## DEPARTMENT OF PUBLIC WORKS

### MEMORANDUM

TO: All Staff  
FROM: Public Works Plan Review Team  
DATE: June 11, 2021  
SUBJECT: LPF-20-00005 (Forest Ridge Ph1)

DWN BY T.S.	DATE 01/2021	JOB NO. 18069
CHKD BY M.K.K./D.L.P.	SCALE 1" = 100'	SHEET 4 OF 6

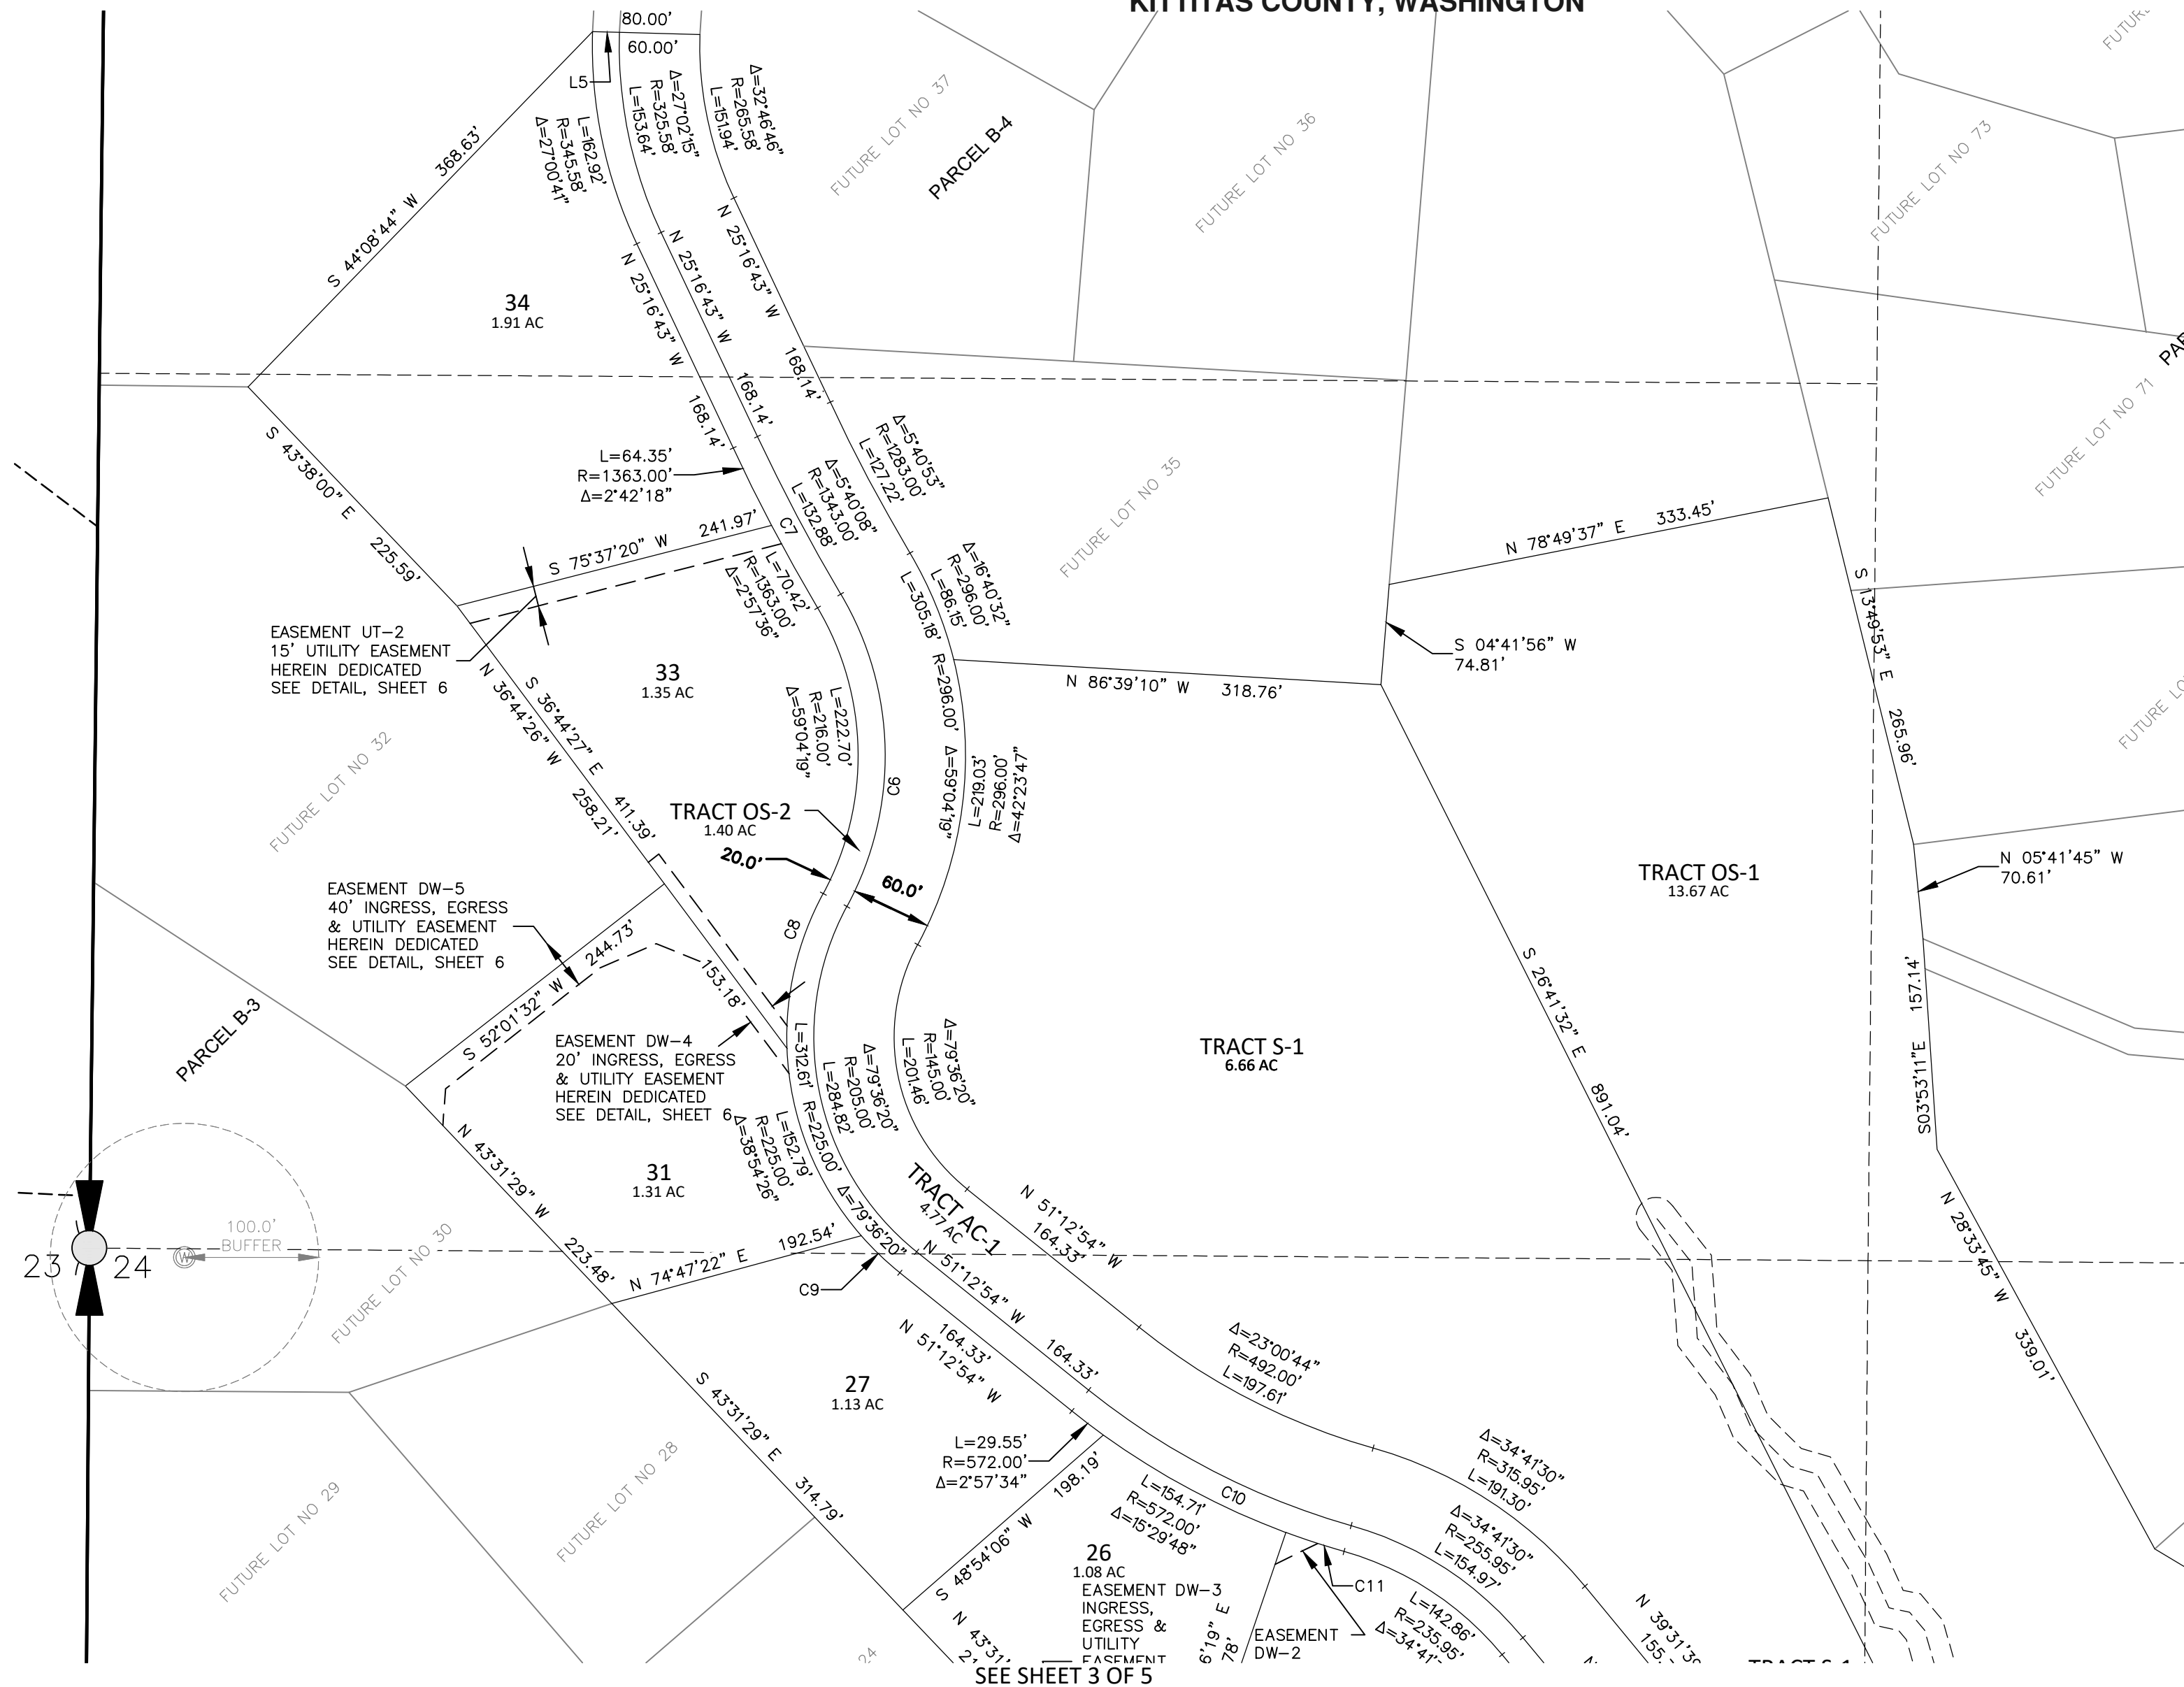
1. The text "100' Buffer" on Sheet 5 located near the West  $\frac{1}{4}$  corner of Section 24 is obscured by crossing linework.
2. The text  $47^{\circ}14'18''$  on Sheet 4 located at the North boundary on Future Lot 18 is obscured by crossing linework.
3. The text "C4" located near the Easternmost corner of Lot 34 should be removed.
